**Response to Planning application from Hertfordshire County Council (T and CP GDP Order 2015)**

District ref: 6/2023/1099/PN15  
HCC ref: WH/16930/2023  
HCC received: 14 July 2023  
Area manager: Manjinder Sehmi  
Case officer: Gideon Gasinu

Hatfield Avenue Hatfield Business Park Hatfield AL10 9FY

Proposed telecommunications installation: Proposed 15.0m Phase 8 Monopole and associated ancillary works

Title: **211 VIS SPLAY PLAN**

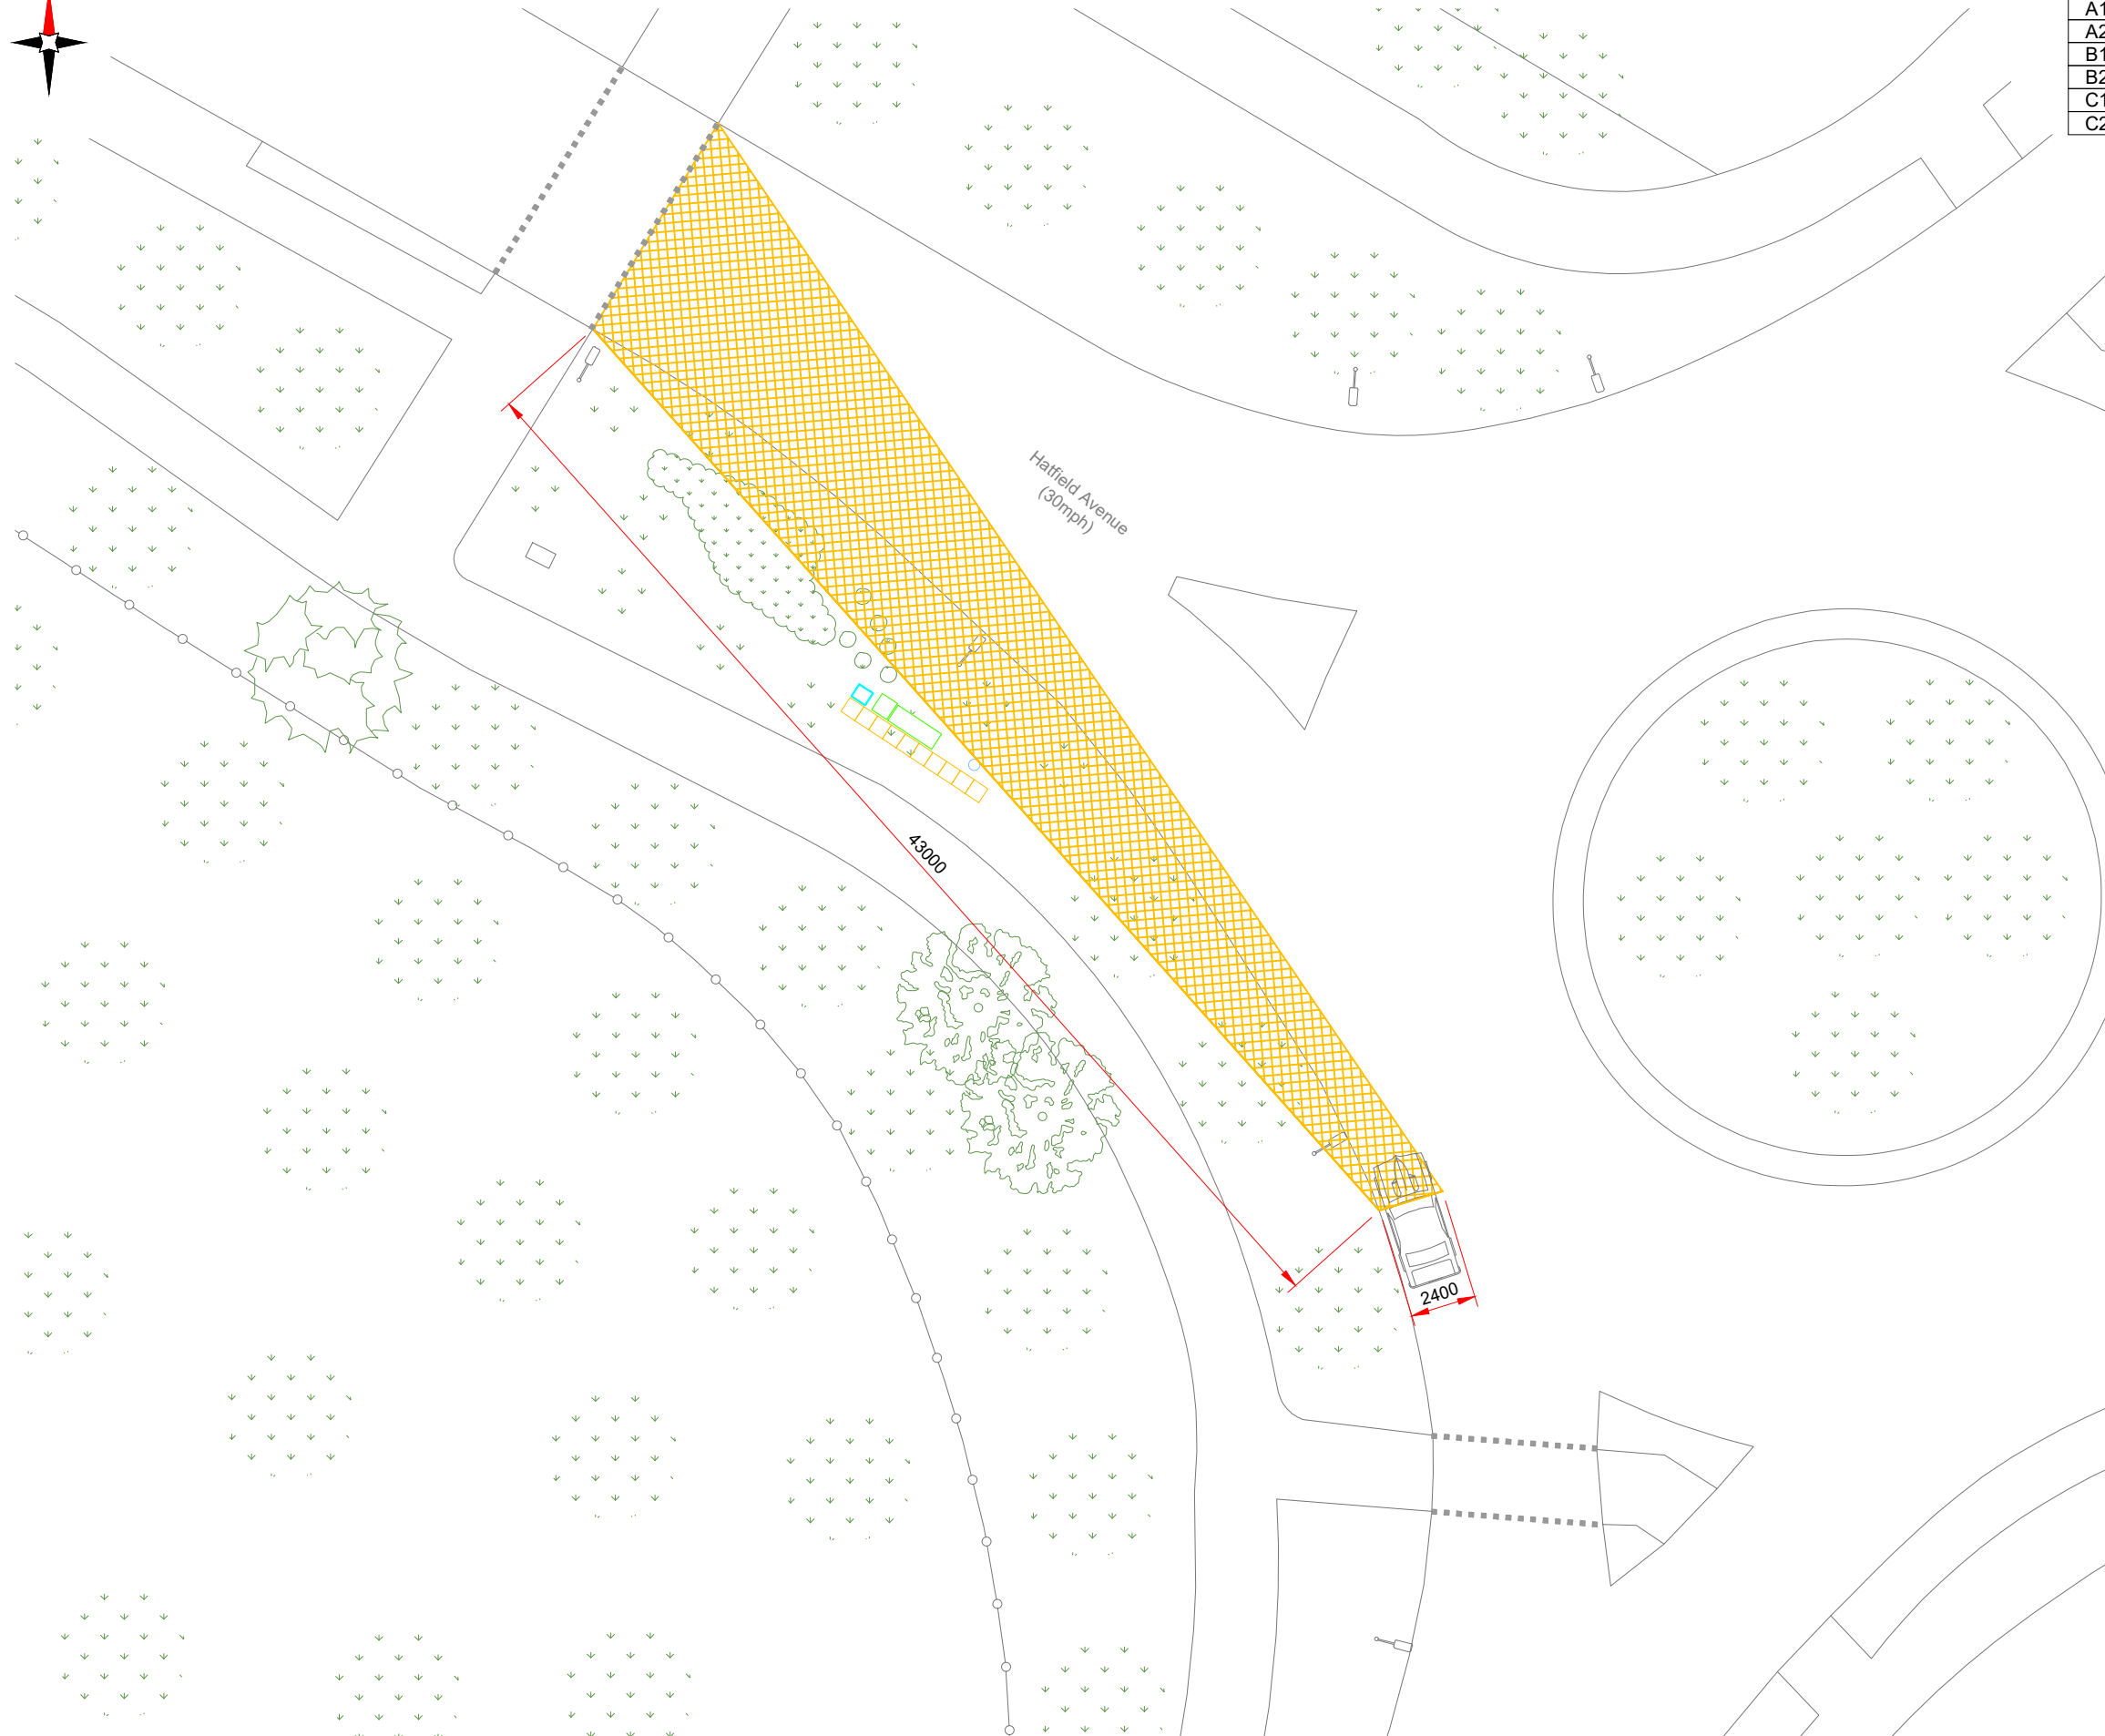
There is insufficient information supplied with this application to enable the Highway Authority to reach a recommendation. In the absence of the necessary information, the Highway Authority recommends refusal due to doubt over possible implications for highway safety and convenience. Reason for Refusal: Submitted splay plans does demonstrate the proposed location is outside the limits of visibility.

The Highway Authority notes the submission of additional information WEH22203\_M002 Rev B which shows visibility splay information.

The drawing provided is inaccurate and should be amended in line with Figure 3.59 of DMRB CD 116 which shows that the visibility envelope should be measured at a distance, thus half of the approach lane width, from the stop line to the crossing point.
